**From:** Rutterford, Beth - E&E  
**Sent:** 18 May 2020 16:18  
**To:** Planning <[Planning@Cherwell-DC.gov.uk](mailto:Planning@Cherwell-DC.gov.uk)>  
**Subject:** Planning Response for 20/01196/F- Public Rights of Way

**From:** Rutterford, Beth - E&E  
**Sent:** 09 September 2019 10:15  
**To:** [DM.Comments@cherwell-dc.gov.uk](mailto:DM.Comments@cherwell-dc.gov.uk); Planning <[Planning@Cherwell-DC.gov.uk](mailto:Planning@Cherwell-DC.gov.uk)>  
**Cc:** Rutterford, Beth - E&E  
**Subject:** Planning Response for 19/01531/F- Public Rights of Way

DRAWING TITLE
Details for Crittal doors & windows
Ground Floor

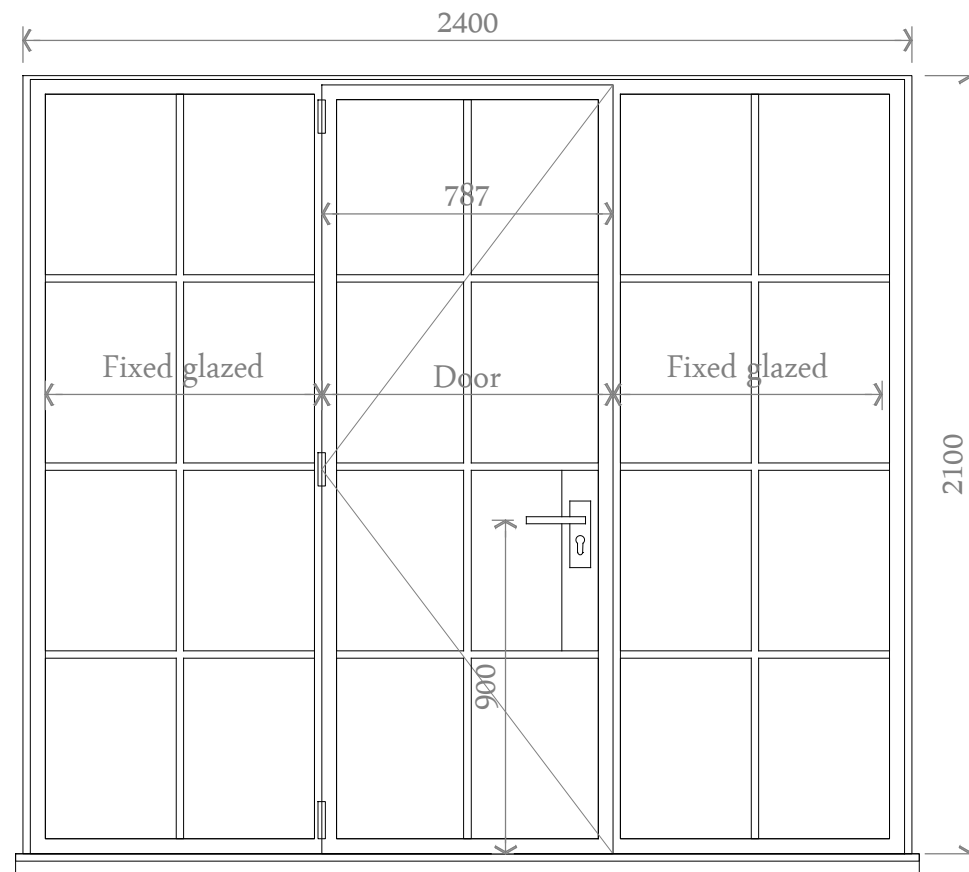
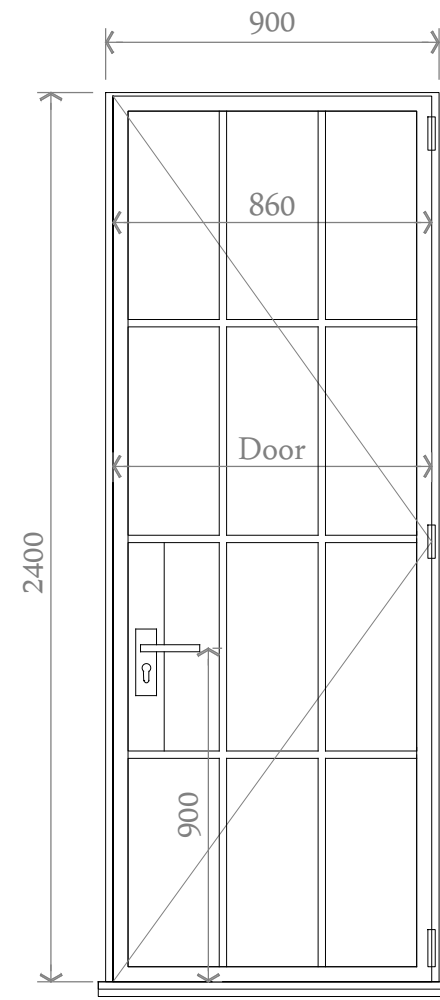
Sibford Ferris Footpath 10 runs to the Western side of the buildings. The width of this footpath is not limited to the surfaced track but is assumed to include the full width between the boundary walls/buildings. Therefore not doors or gates should open outwards onto the footpath as appear to be shown in the plans. No other objects should be placed here.

5. **Gates / right of way:** Any gates provided shall be set back from the public right of way or shall not open outwards from the site across the public right of way. Reason: To ensure that gates are opened or closed in the interests of public right of way user safety
